Our Ref: FP/251/19/PL
Your Ref:

Development Altering of existing west access to site to allow for vehicular access for emergency & maintenance purposes only. Drop kerb formed to allow for vehicular crossover, area to include a new area of secure bin storage for the school.
fence off waiting area separating it from public access & existing vehicular entrance areas.

Location Bishop Tufnell C Of E Junior And Infant School Pennyfields Felpham

Thank you for the information you have sent following my previous letter. Unfortunately I am still unable to accept the application as valid until the following items are received or resolved:-

project:	EXTERNAL WORKS		
location:	BISHOP TUFNELL PRIMARY SCHOOL, FELPHAM		
client:	SCHOOL GOVERNORS		
drawing:	SITE PLAN AND BLOCK PLAN		
scale:	1:500, 1:1250	page:	A1
drawn by:	JM	checked by:	AW
date:	NOV 19	drawing number:	2261.7/200
		revision:	A

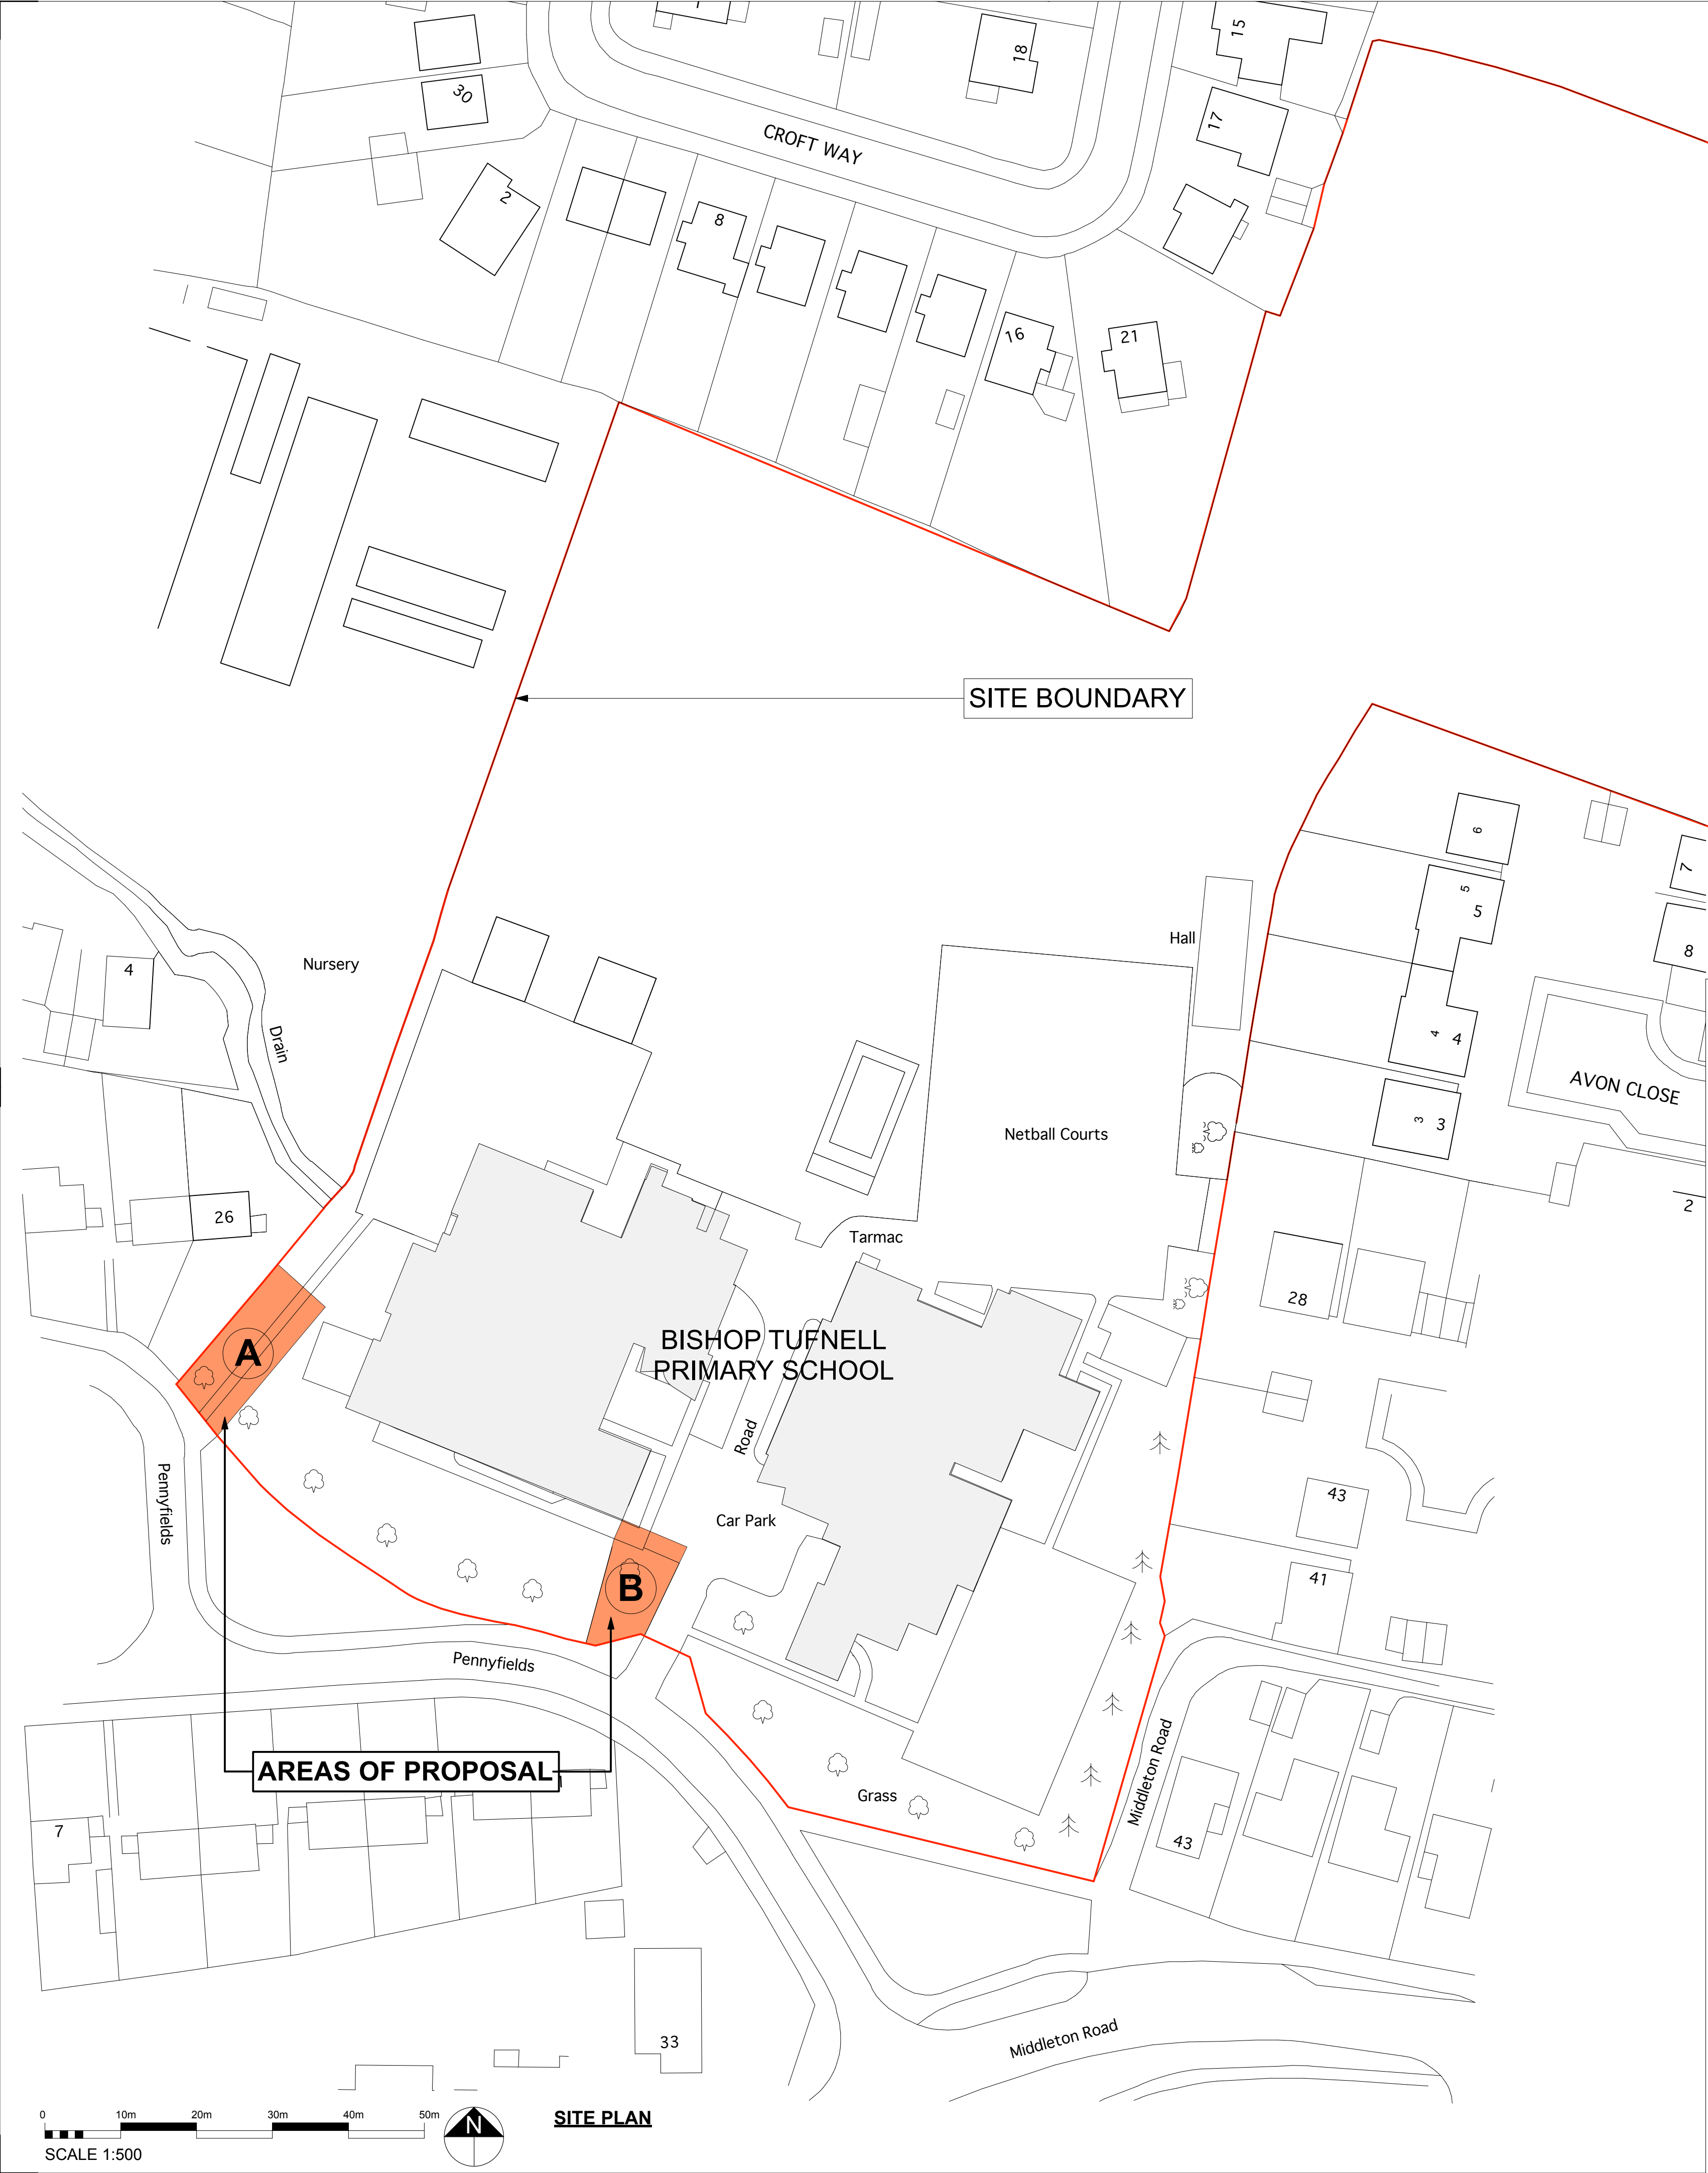
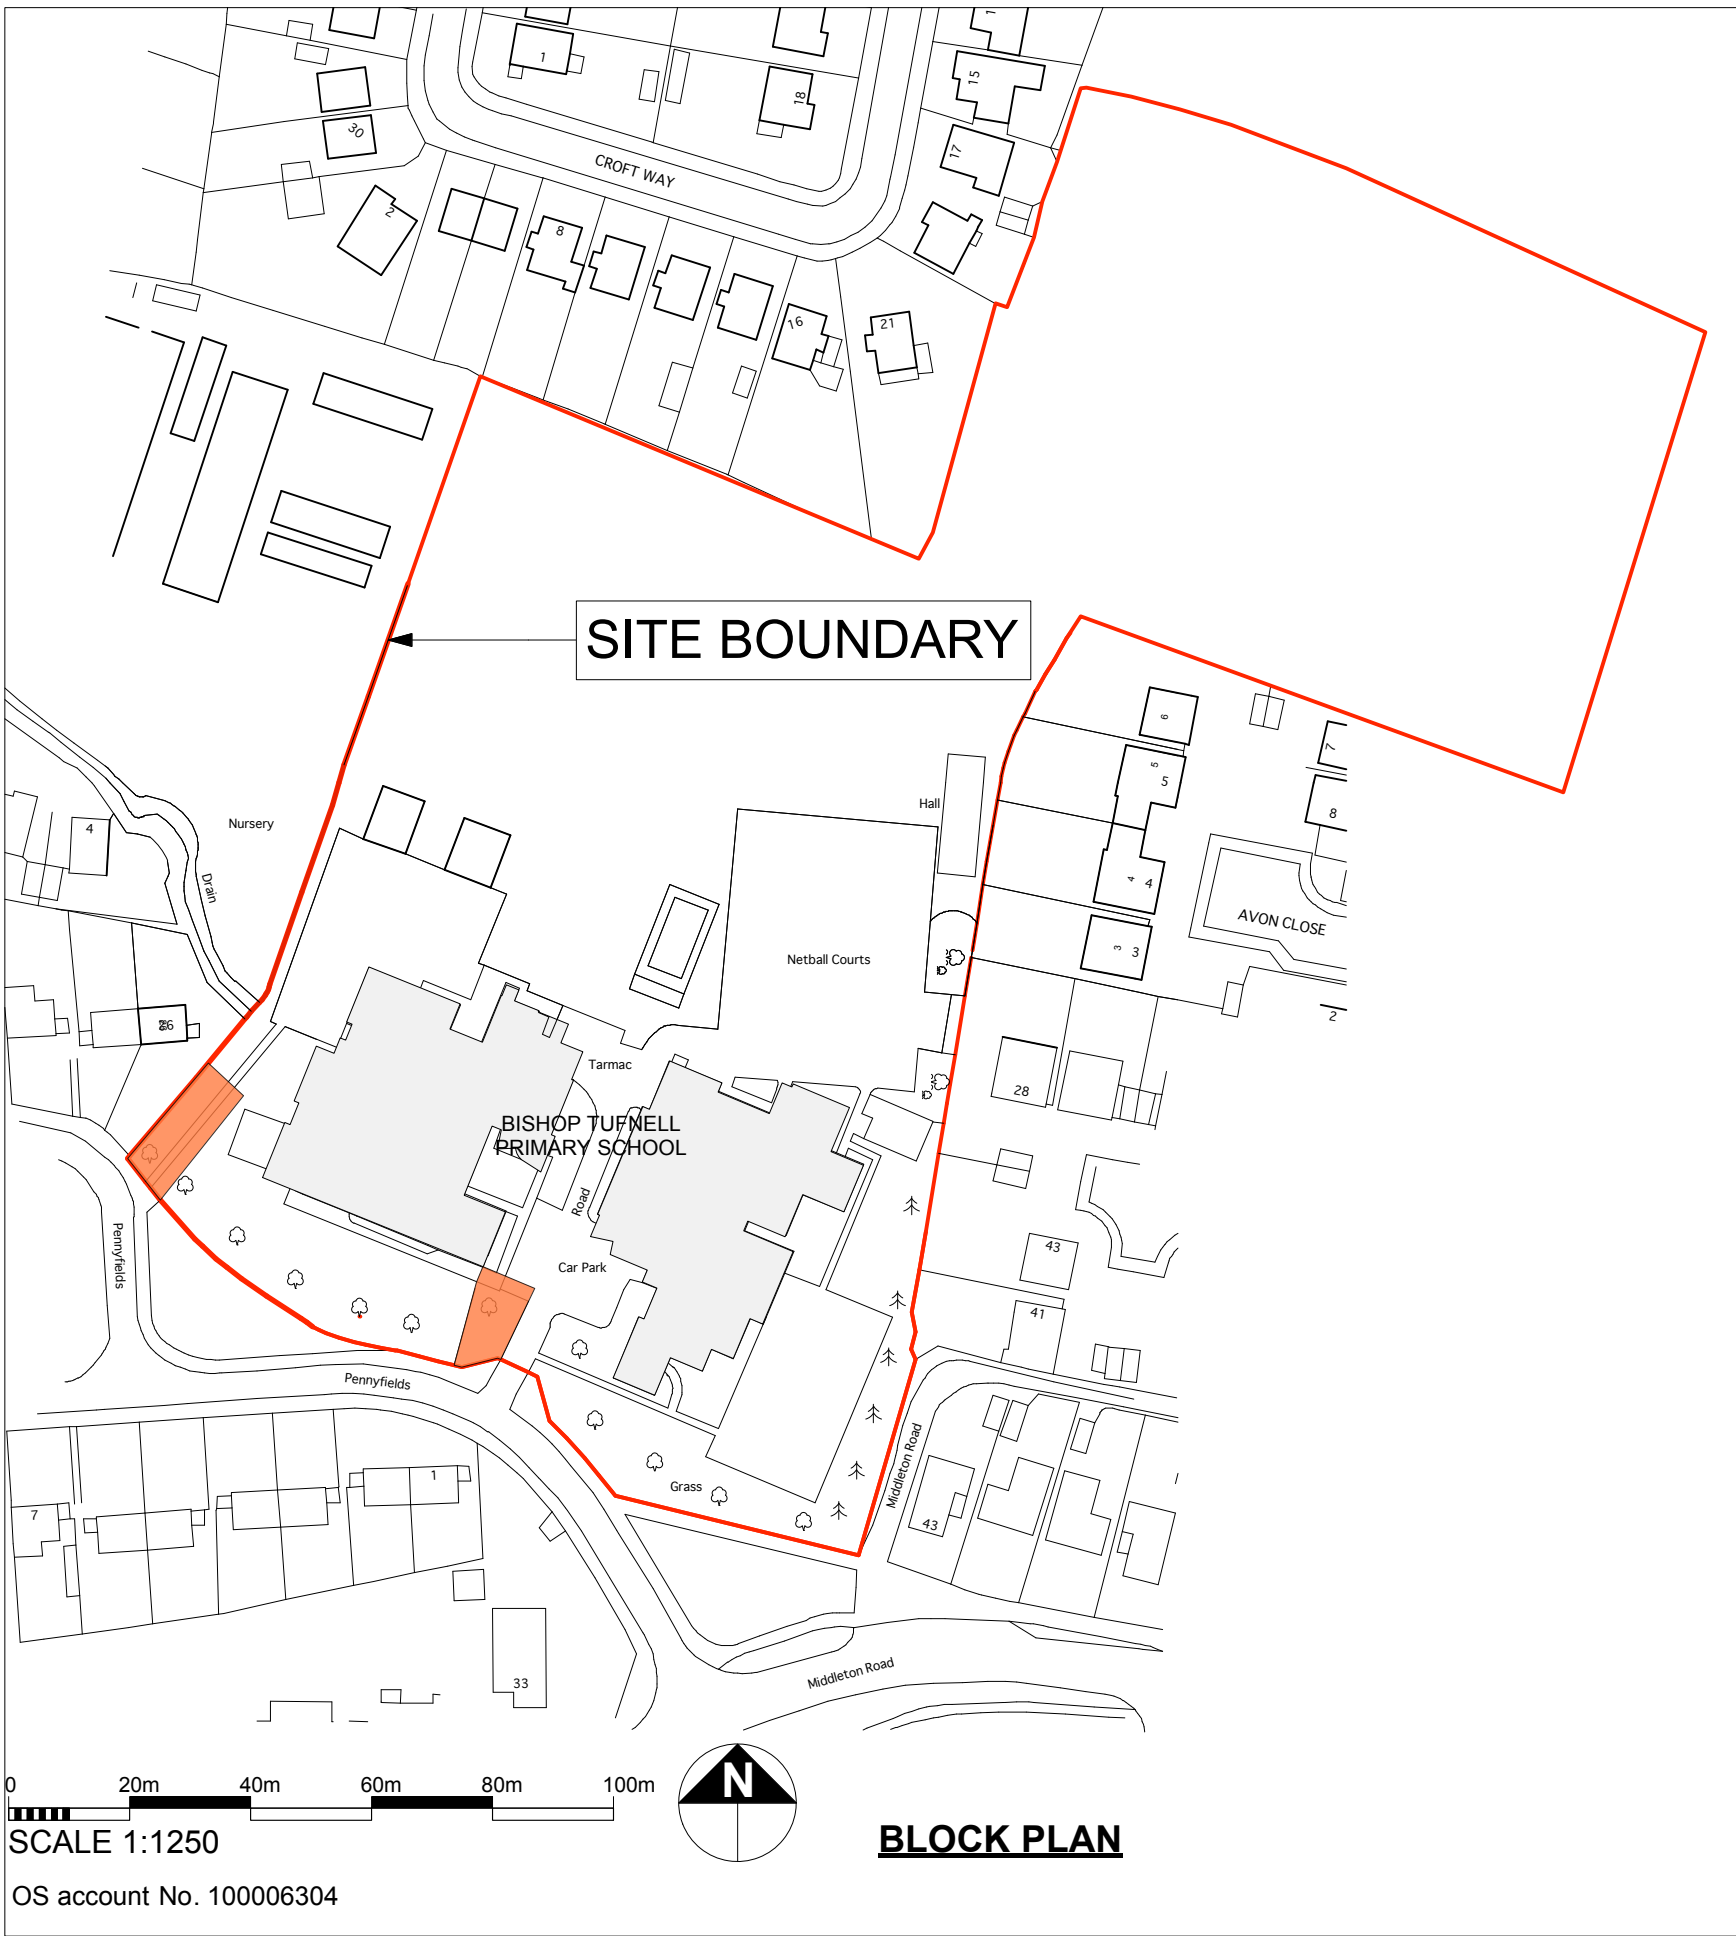
Location Plan Amend

Please provide a complete red edge.

Because you are crossing WSCC land (road) please complete Certificate B and serve notice on WSCC. Please amend the application Certificate A and B to reflect this change.
